HALL STREET BONDI DEVELOPMENT

ACCESSIBILITY REVIEW

Morris-Goding Accessibility Consulting

27th May 2008

Basement Carpark Level 003
1:400@A3

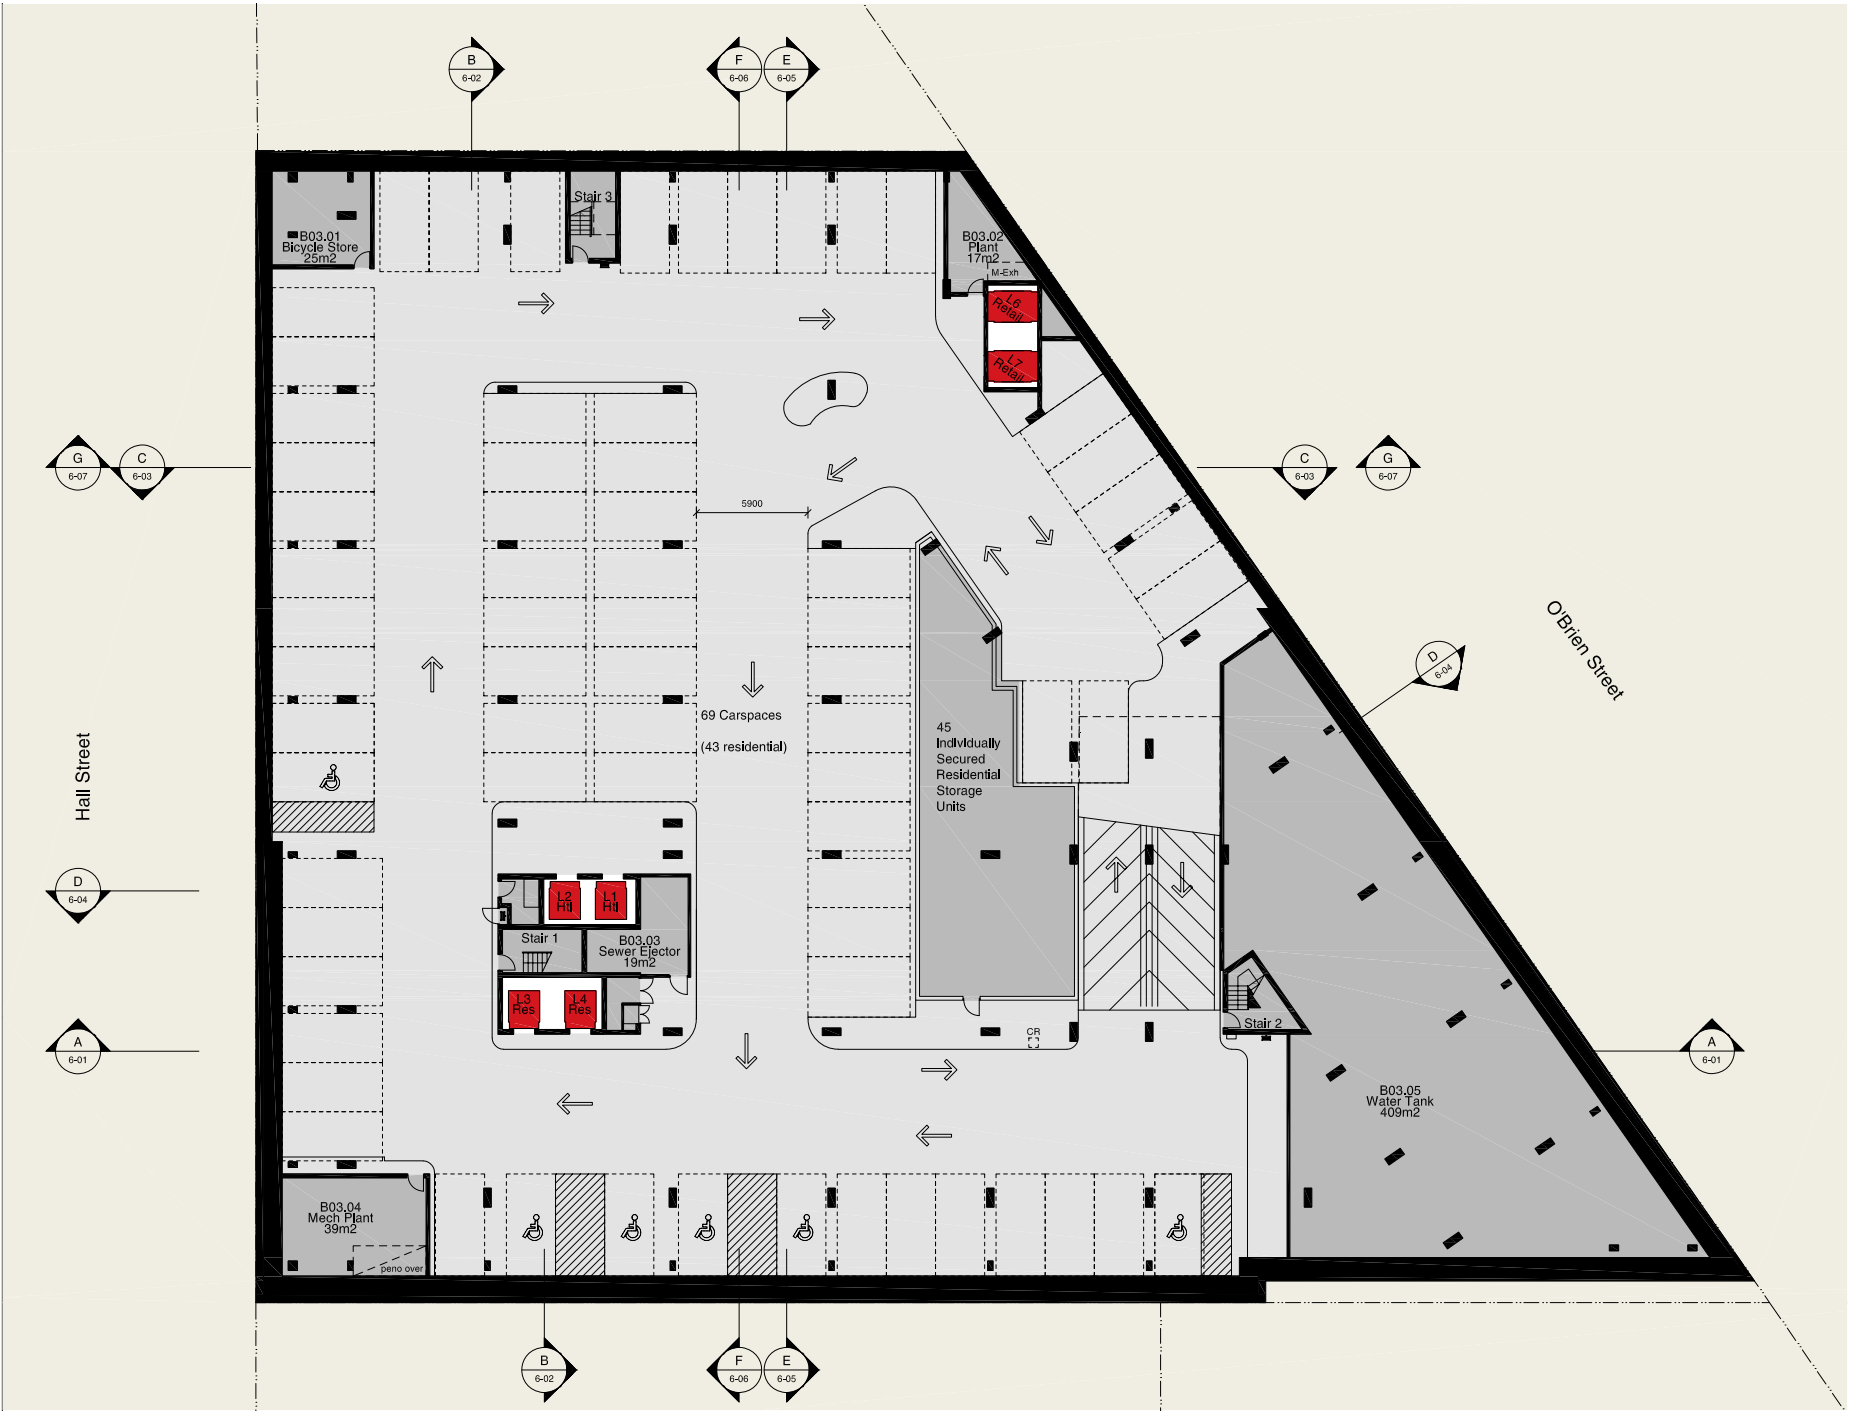
There are 3 adaptable unit car bays located on basement level 003. The width and number of these car bays is in accordance with AS4299.

- (i) All accessible parking shall have a minimum 2500mm height clearance compliant with AS2890.1. The approach to each adaptable car parking bay should not have vertical clearance of less than 2.3mm.

Basement Carpark Level 001
1:400@A3

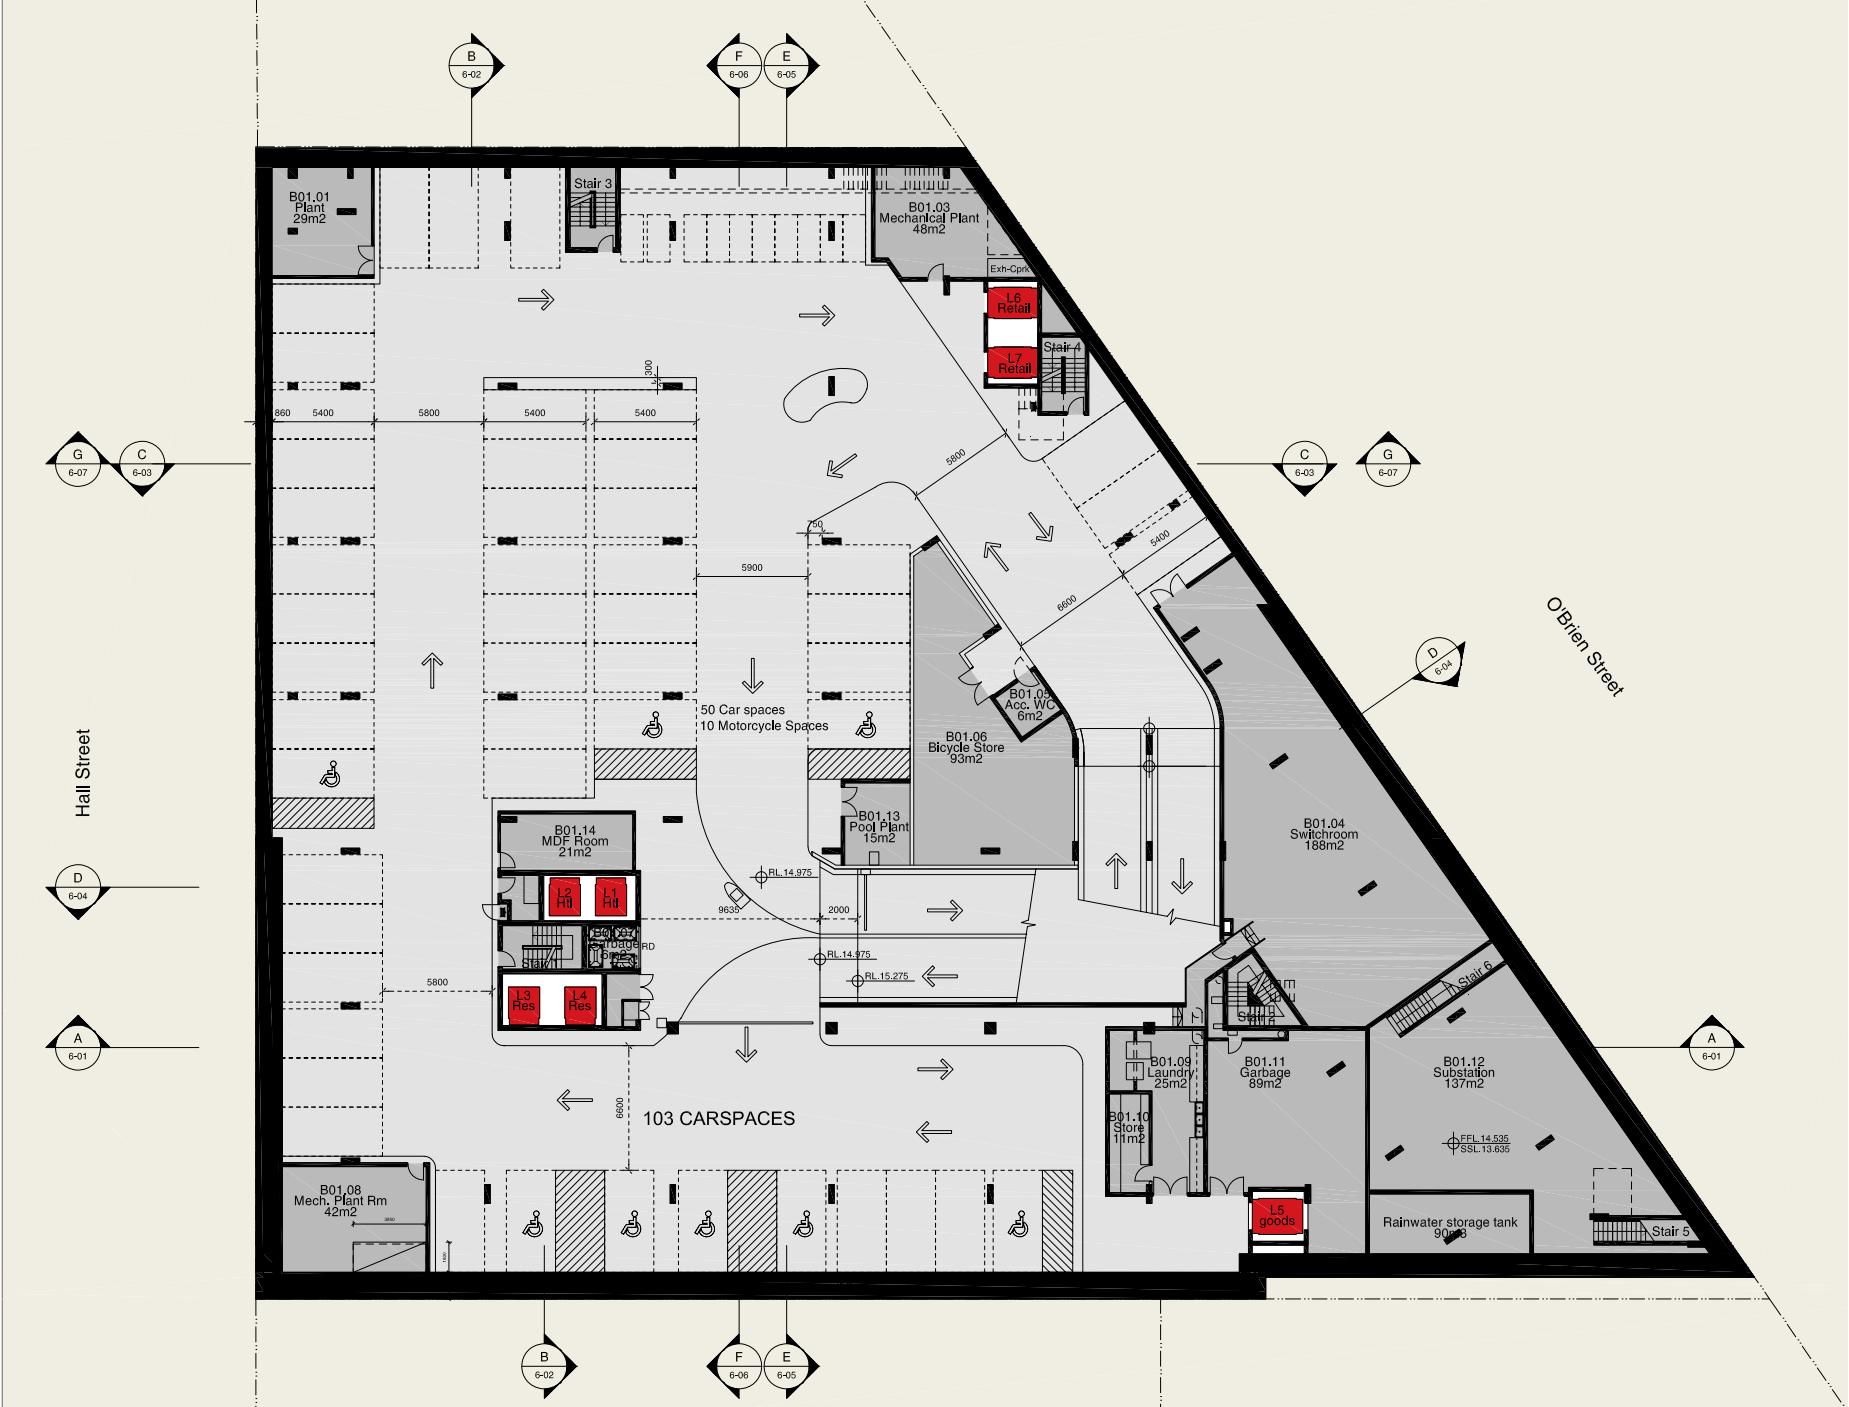
There are 110 retail car bays with 3 accessible car bays located over basements levels 001 and 002. The accessible car bays have 3.2 metre width, which is suitable under AS2890.1. This number of accessible car bays is suitable under BCA part D3 and draft DDA Premises Standards.
